2023/0463

Change of use of the existing retail shop areas into residential use and associated internal and external alterations to the buildings including removal of shop fronts and demolition of existing outbuildings to create 3no dwellings with gardens and parking area to rear in place of 2no shops and 2no dwellings

163, 165 - 167 Midland Road, Royston, Barnsley, S71 4BZ

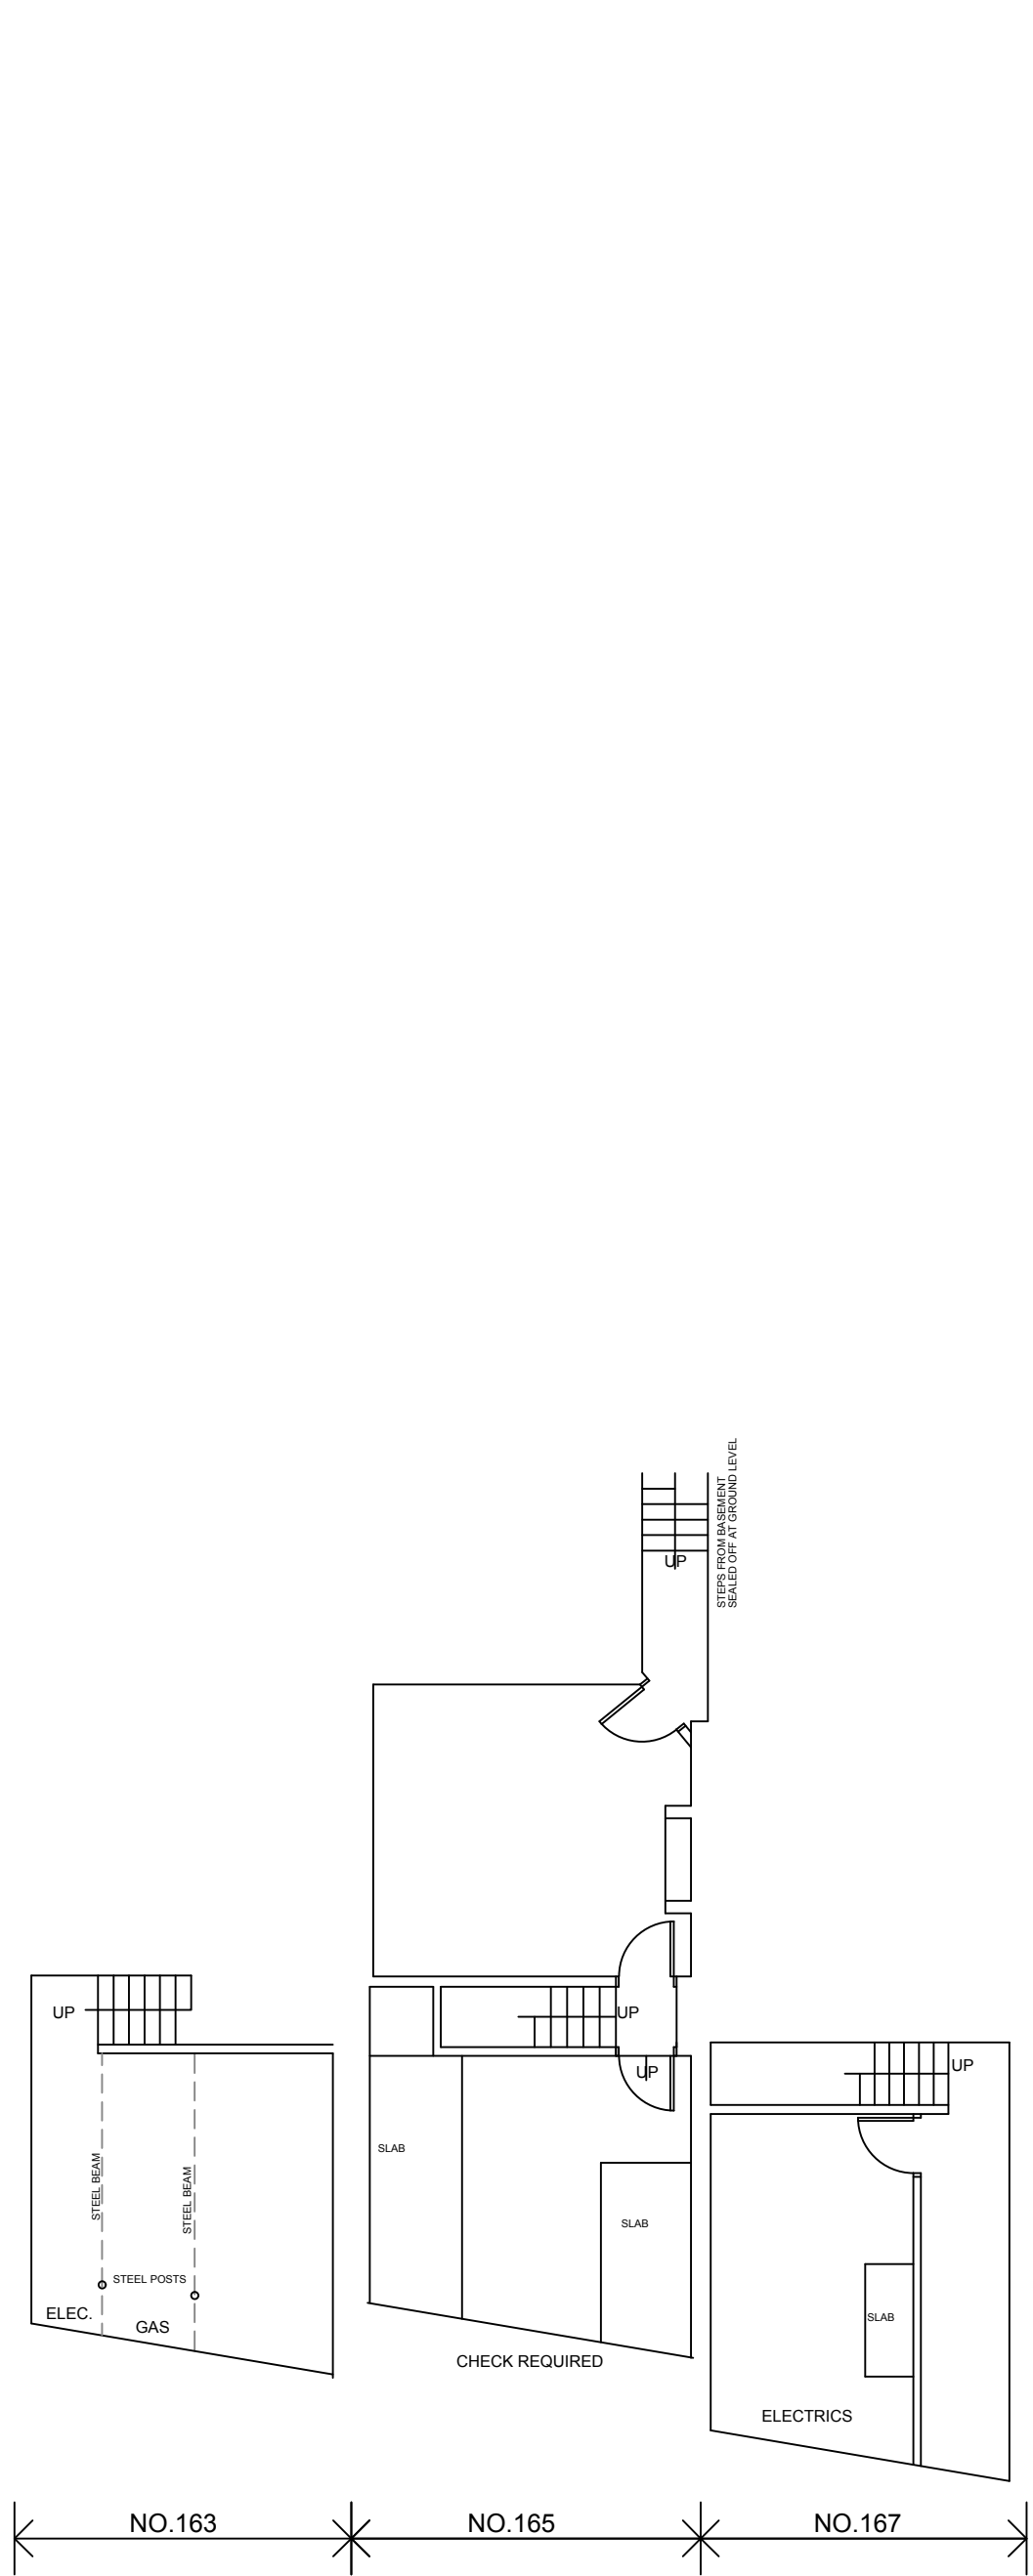
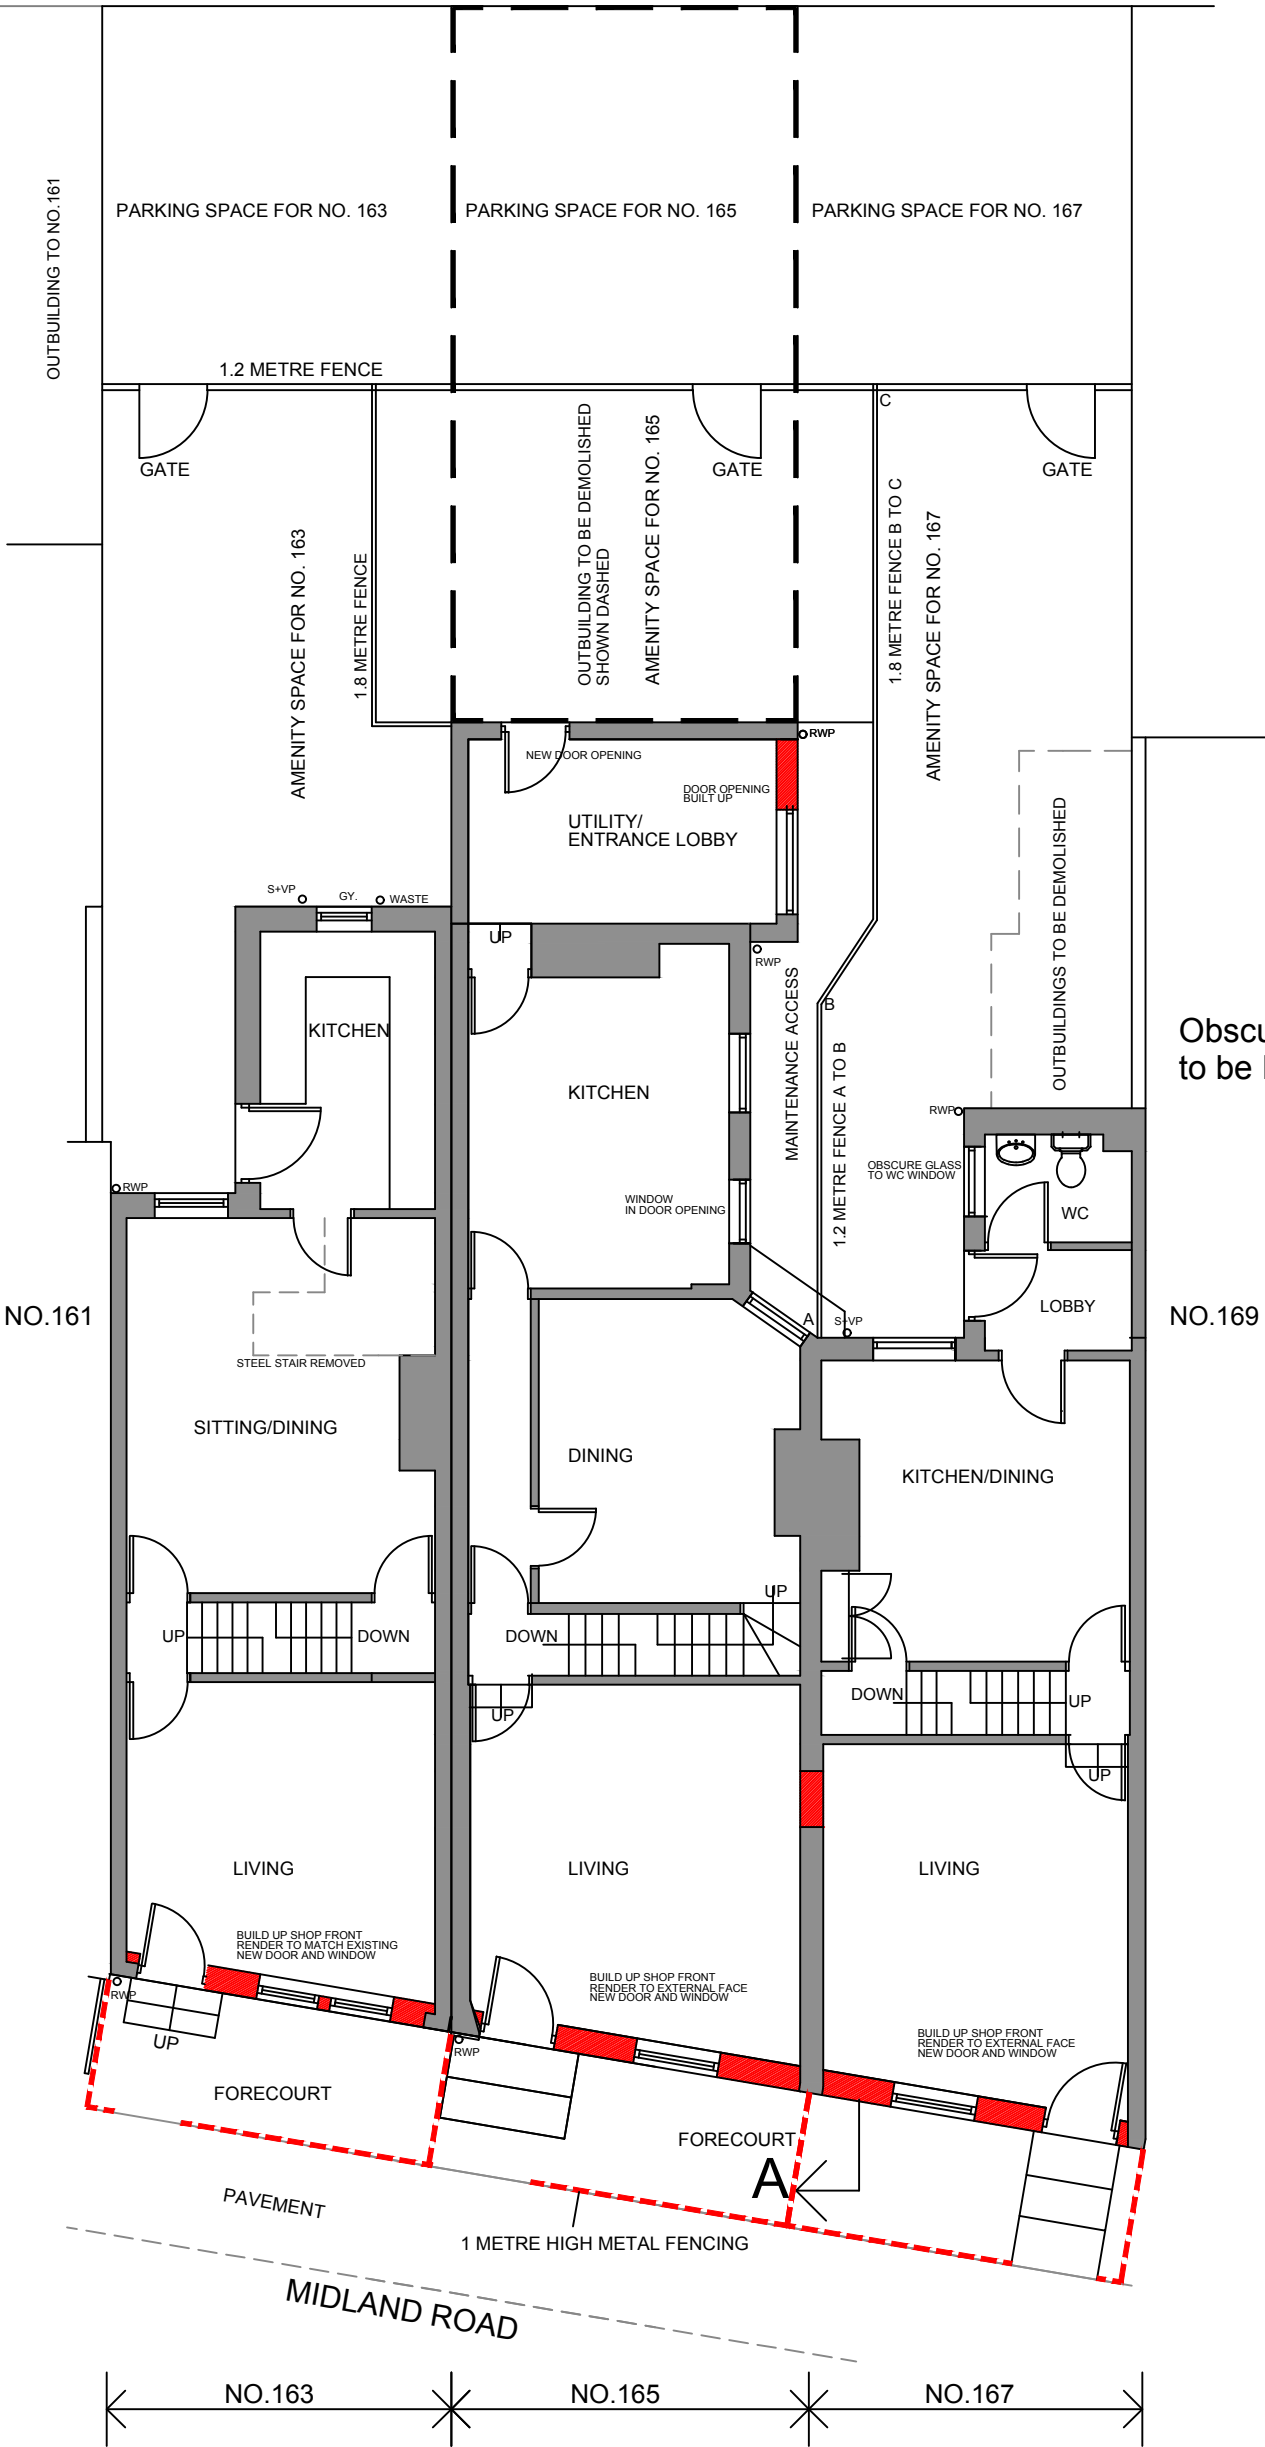
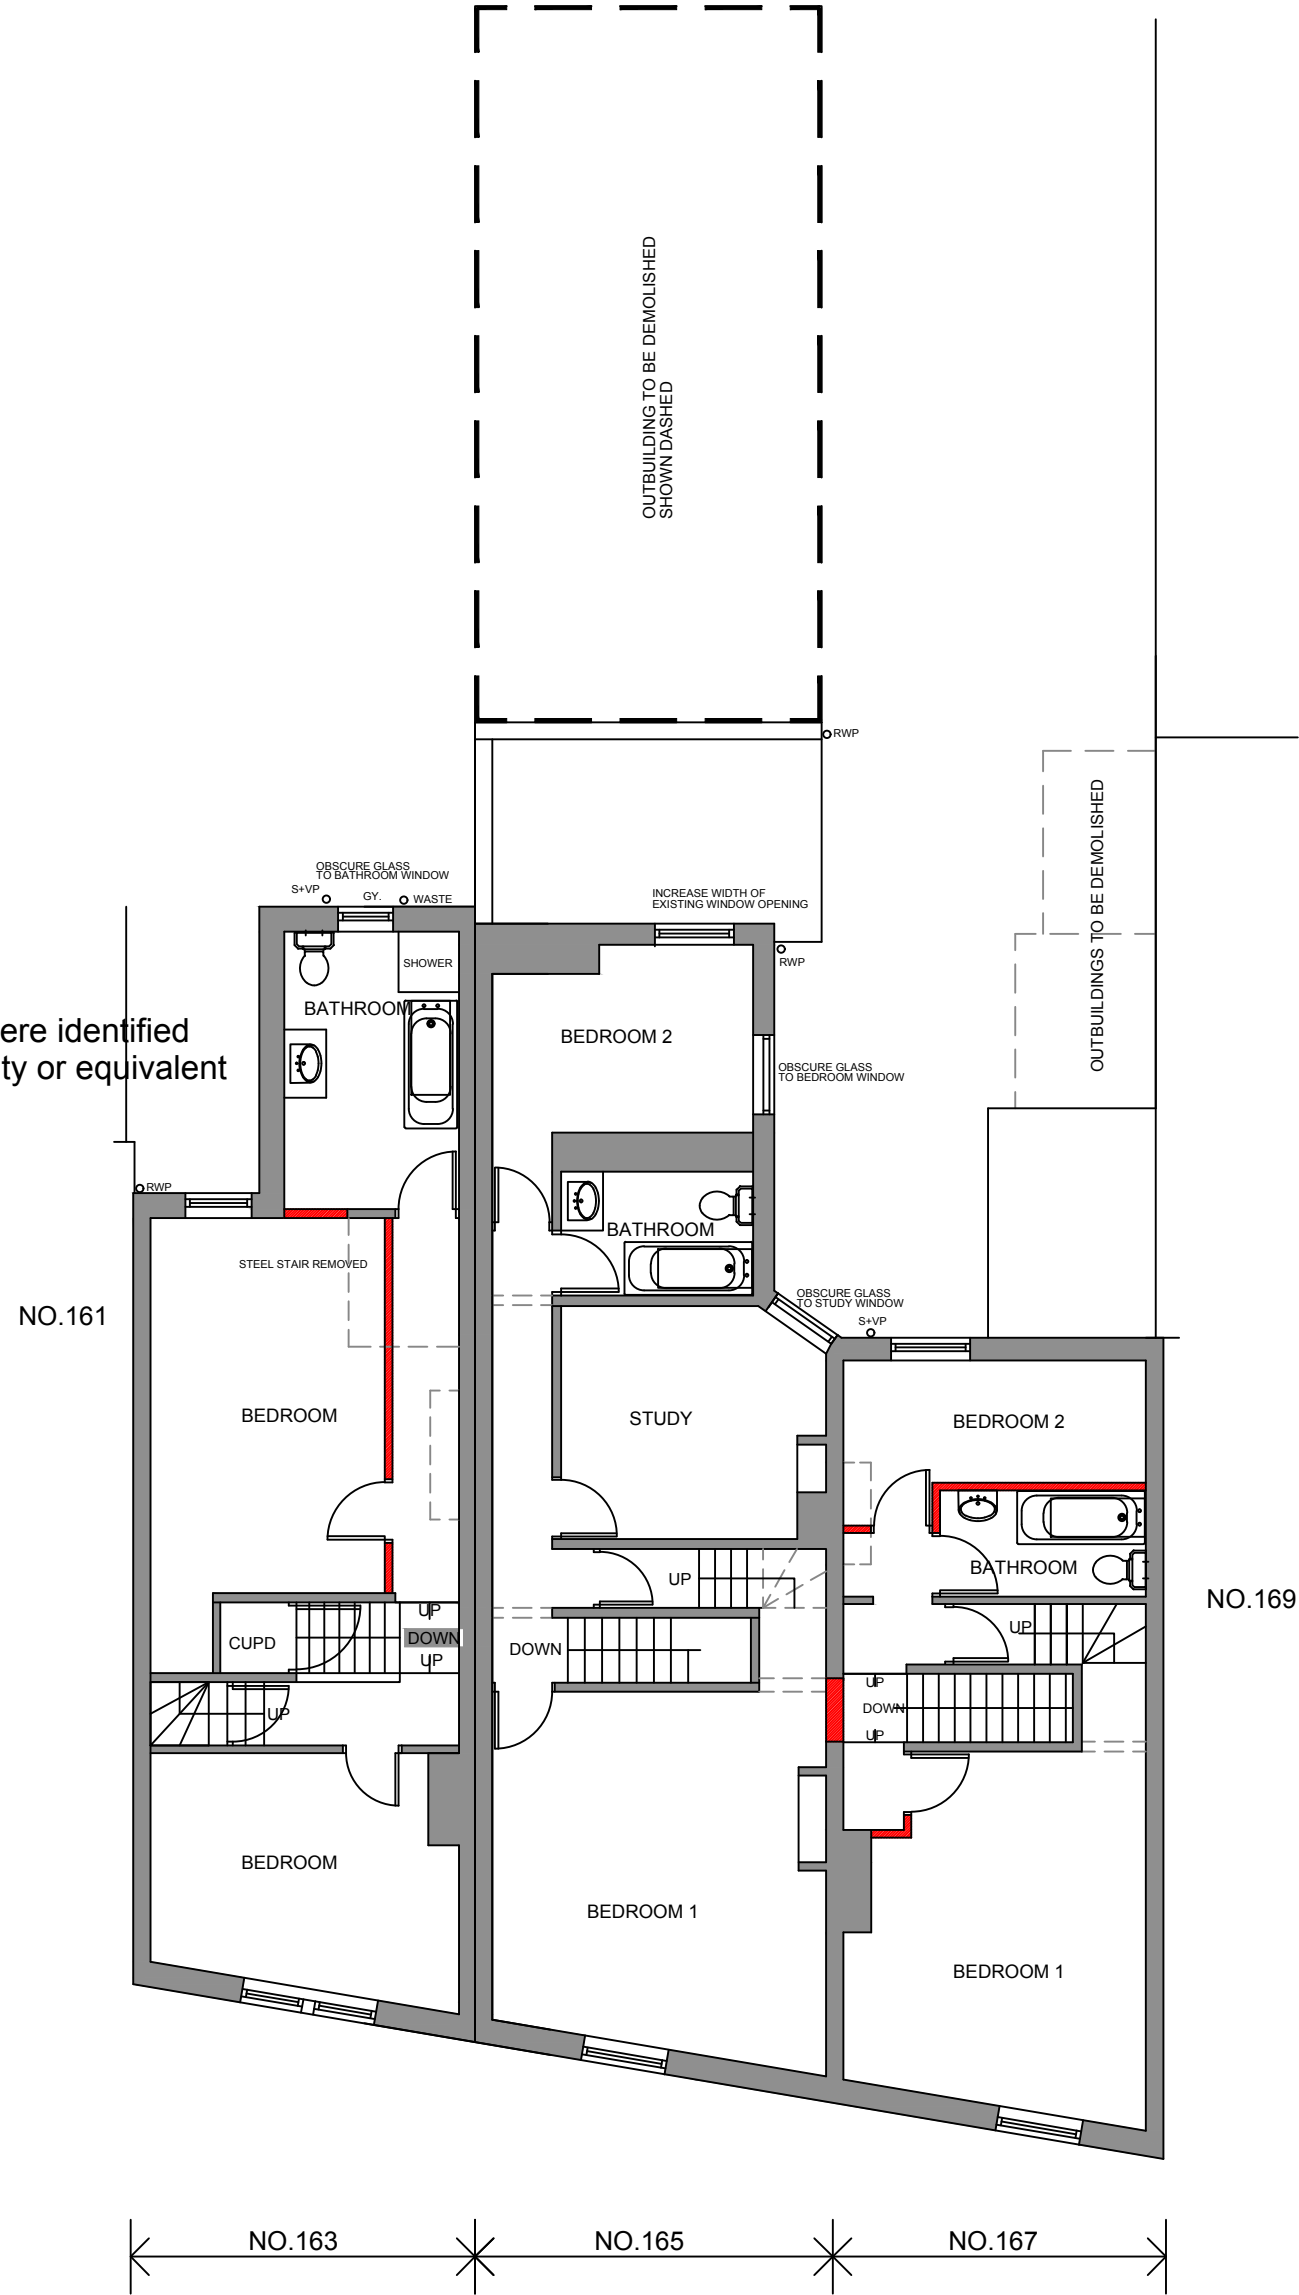
Highways DC – Initially queried various aspects of the development including details of visibility, driveway width, bin storage and turning space. Upon receipt of an amended plan indicating these details, no objection was raised to the scheme subject to a condition relating to hard surfacing of the access and driveway areas.

The proposed private external space falls short of the minimum requirements in the Council's SPD for Design of New Housing Development for three-bedroom properties with no. 163 having 34sqm, no. 165 having 36sqm and no. 167 having 39sqm – which are less than the required 60sqm in the SPD. However, there is inherent difficulty in achieving the required 60sqm given that the development is for a conversion of existing buildings and there is also the requirement to create on-site parking to the rear of the properties, which reduces the proposed external area.

There was initial concern that the proposed plots and placement of windows would result in overlooking to each other's habitable room windows and rear garden areas. To alleviate this impact, several windows will be obscure glazed such as the first-floor windows serving no. 165's study and bedroom 2. A note has been added to the plan to this effect and a planning condition will be added to any forthcoming approval notice. Other windows serving bathrooms will be obscure glazed also for general privacy purposes.

There were also slight concerns raised with the lack of suitable outlook from the proposed dwellings, which would be exacerbated by the erection of boundary fencing in the rear external areas. However, clarification has been provided by the amended plans which show that the fencing between nos. 165 and 167, immediately adjacent to the dwellings themselves will be limited to a height of 1.2m to allow for some outlook from both properties. This will mean that the properties are not entirely private but this relationship between the three properties is similar to that of other terraced housing in the Borough, and in the local area which Midland Road is characterised of.

The proposed dwelling all have one parking space to the rear of each plot site which is less than the required two parking spaces within each three-bedroom plot as required by the Council's SPD for Parking. However, Highways DC have been consulted and have allowed some flexibility given the central location of the site within the District Centre of Royston, the close proximity to local public transport links and the character of the area with the vast majority of properties on Midland Road not featuring any off-street parking. Additionally, the existing properties contain residential units in the first and second floor with two-bedrooms which do not benefit from any off-street parking, and the proposed parking arrangement is considered to be appropriate.
